Application for Planning Permission for Works or Extension to a Dwelling

Development: Two storey front extension, first floor side extension, single storey side extension, two storey side extension, conversion of roofspace to habitable use with rear dormer and installation of 4 x balconies.

Location: 45 Southdean Close Middleton-On-Sea PO22 7TH

PROPOSED SITE PLAN
Sc. 1:500

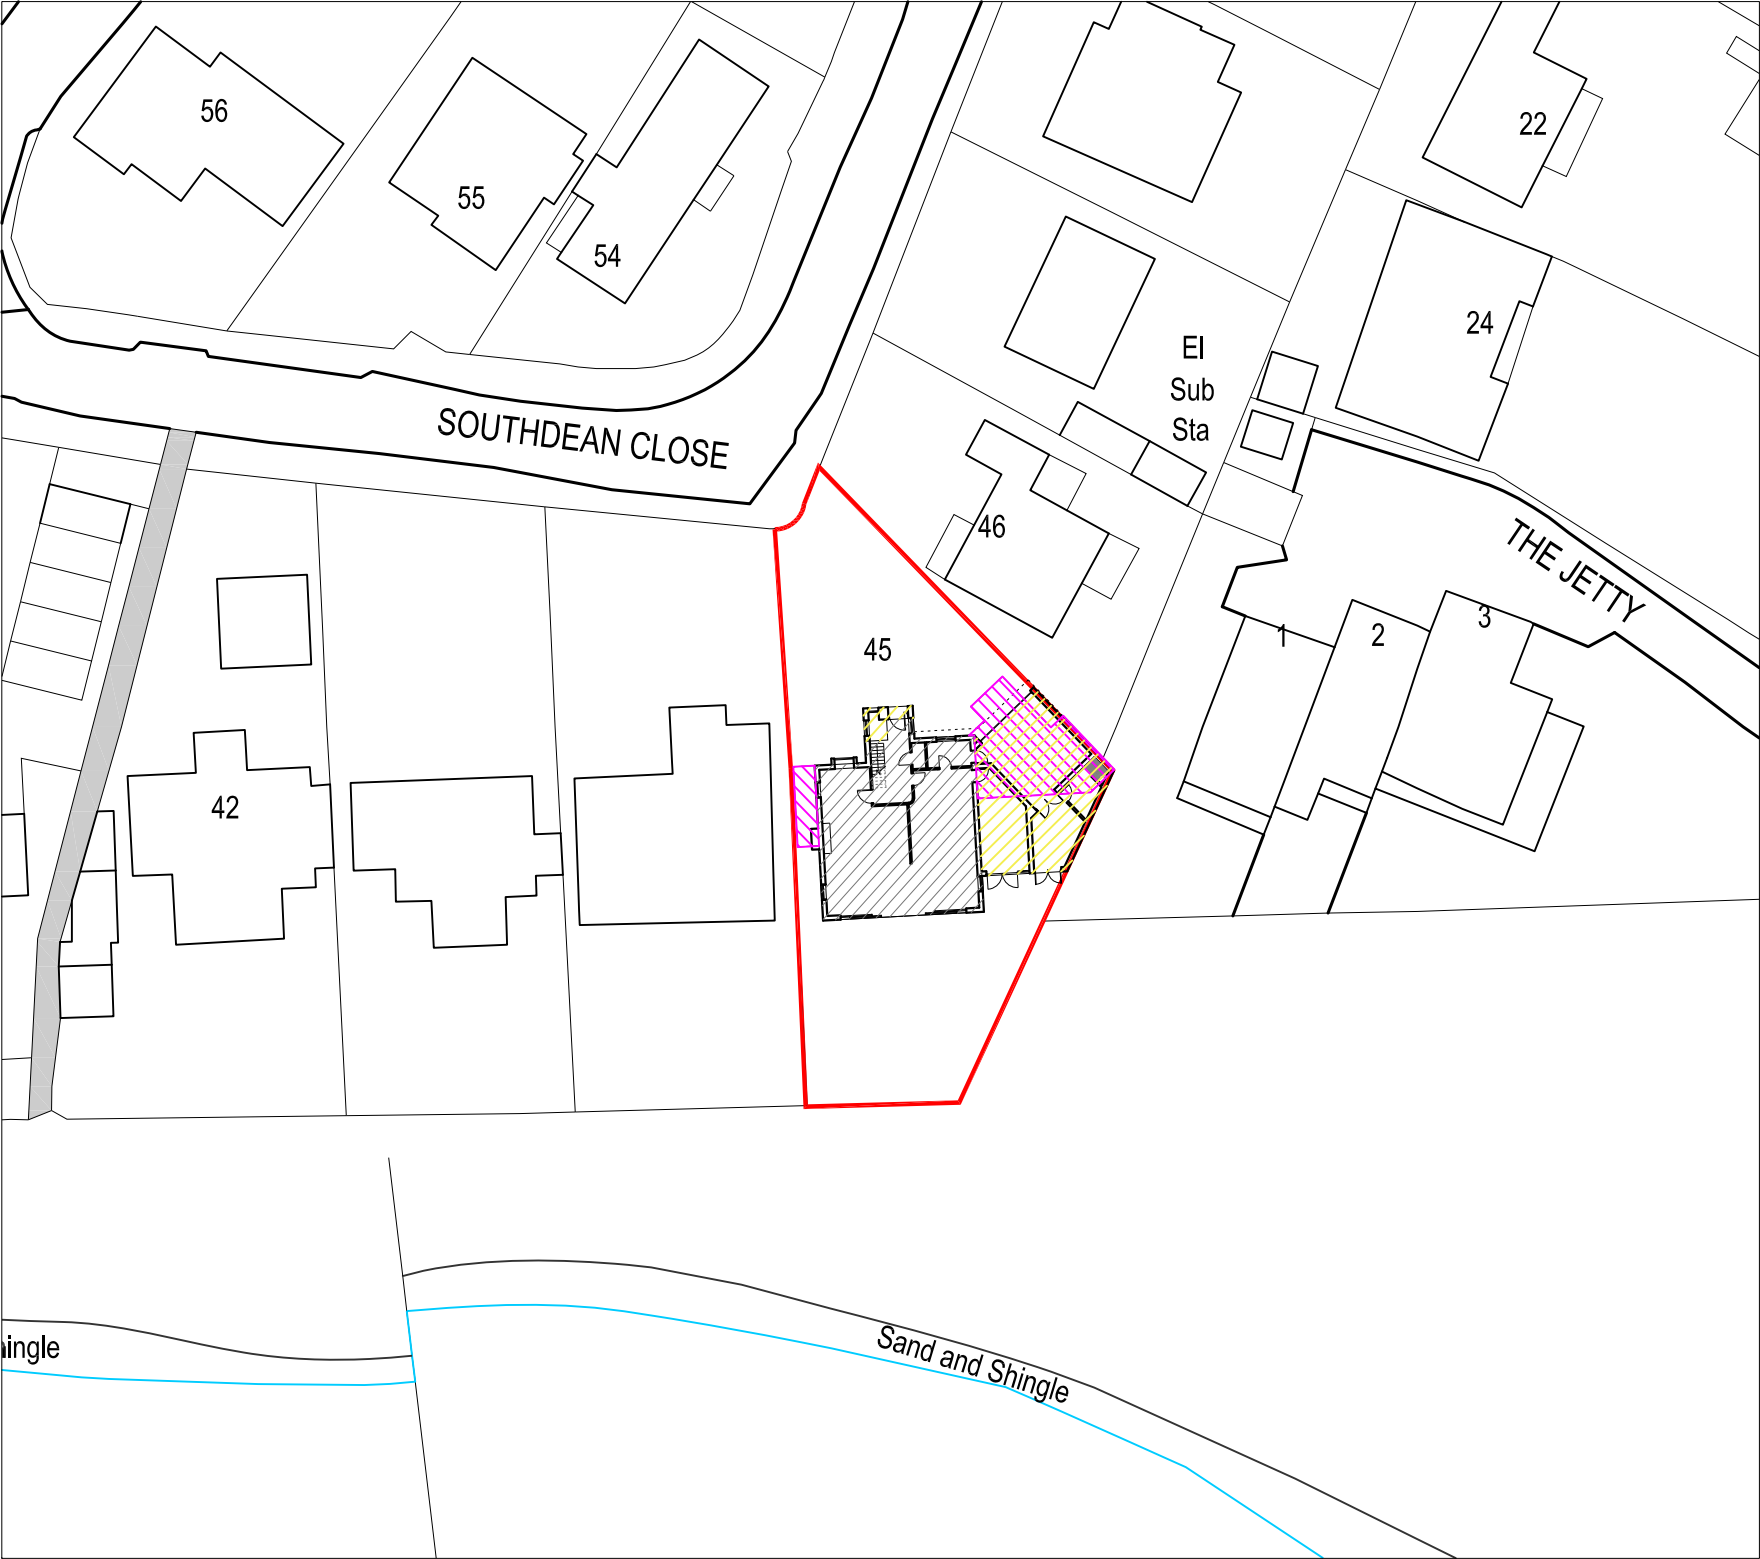
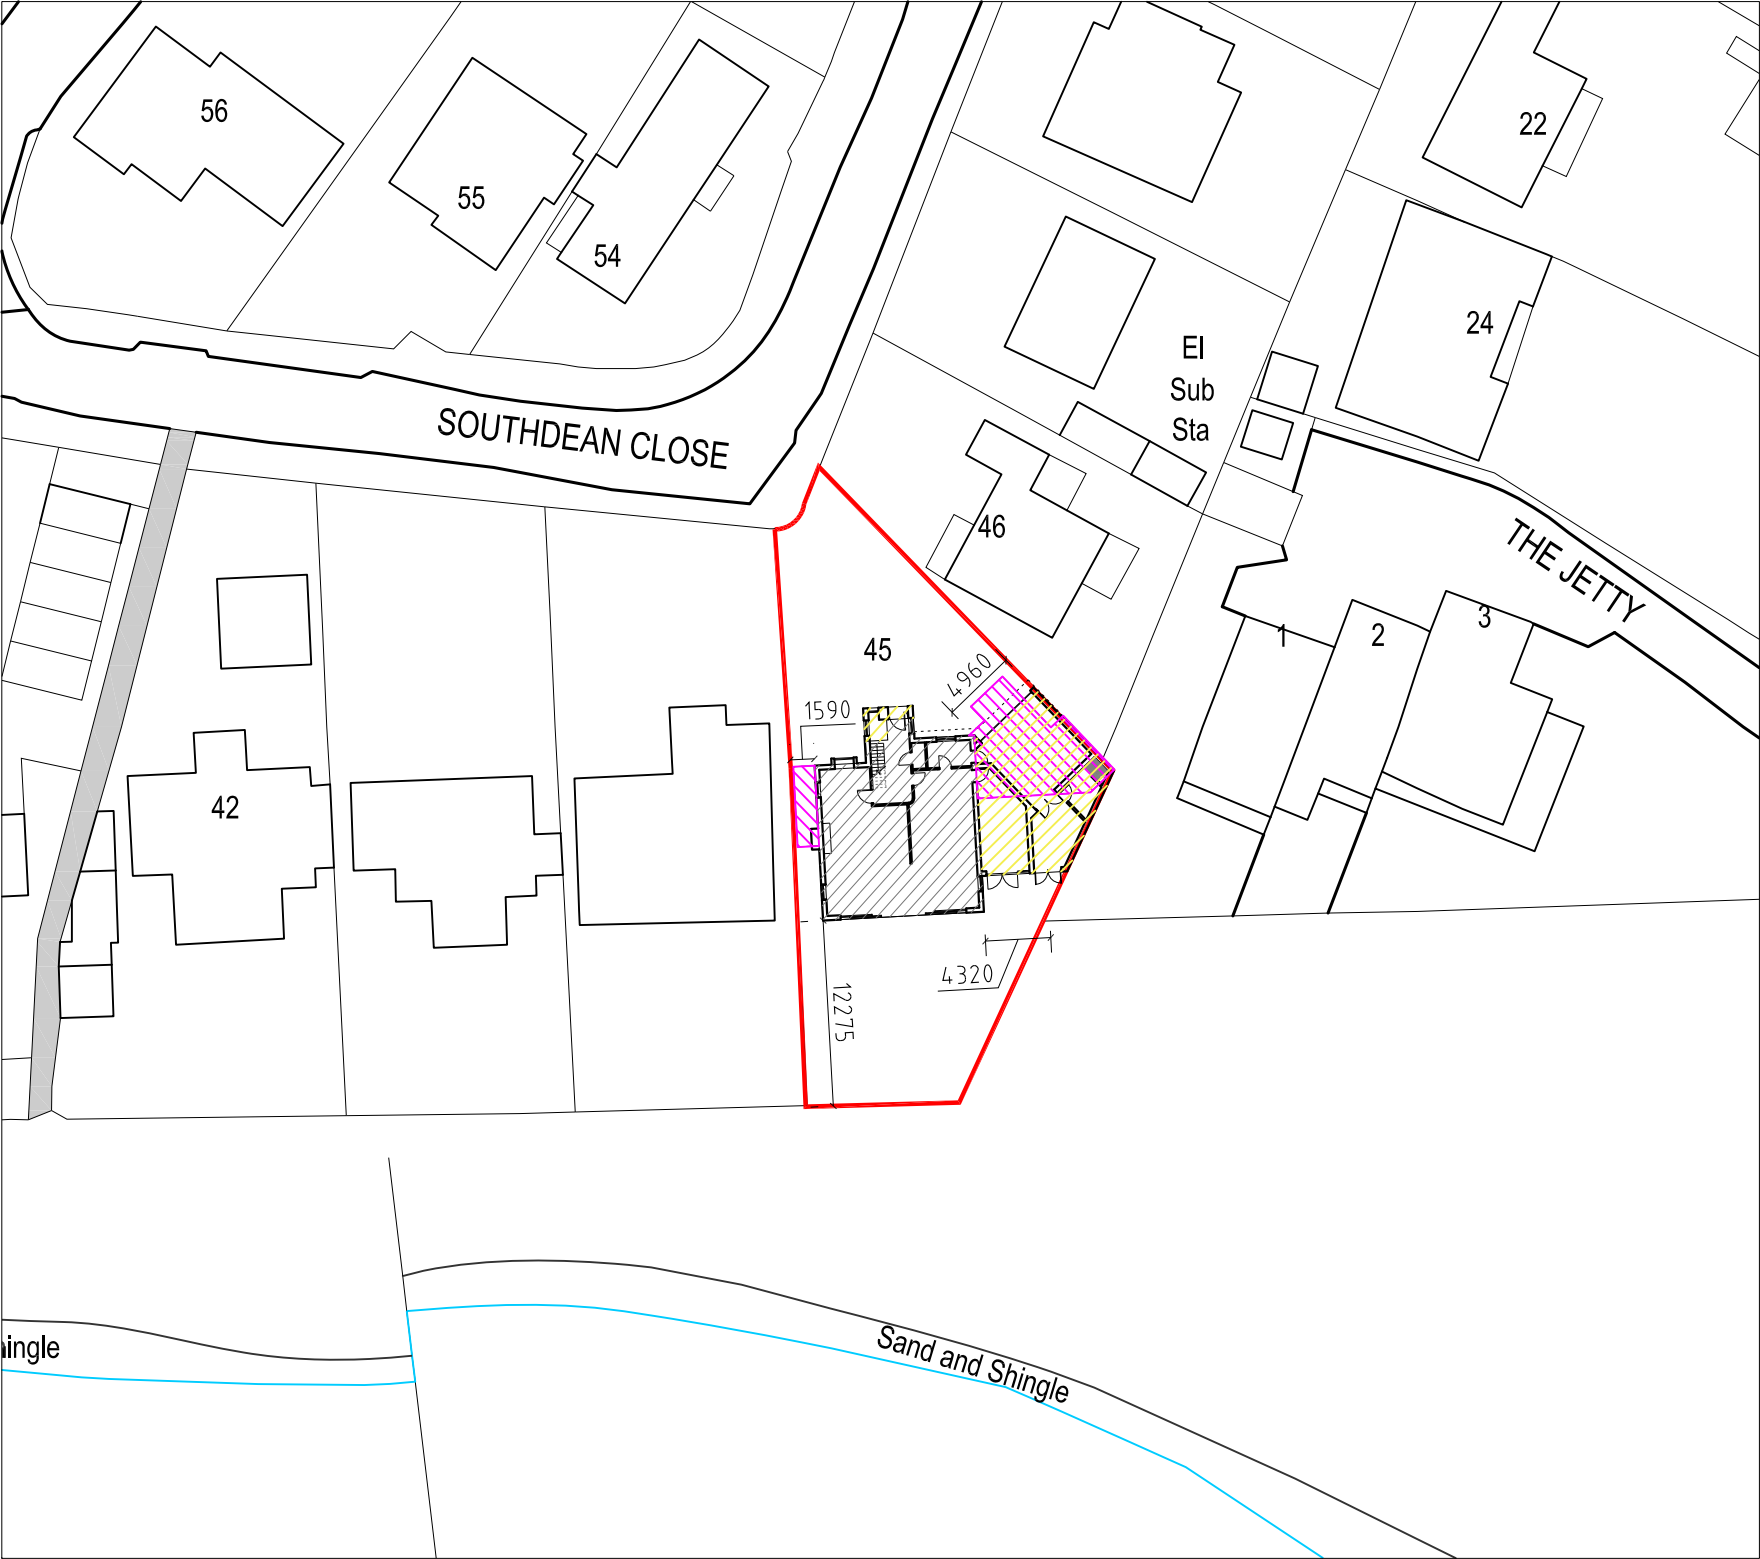
Dimensions: You are required to include dimensions from the proposed extension to all site boundaries on the proposed block plan. Please amend
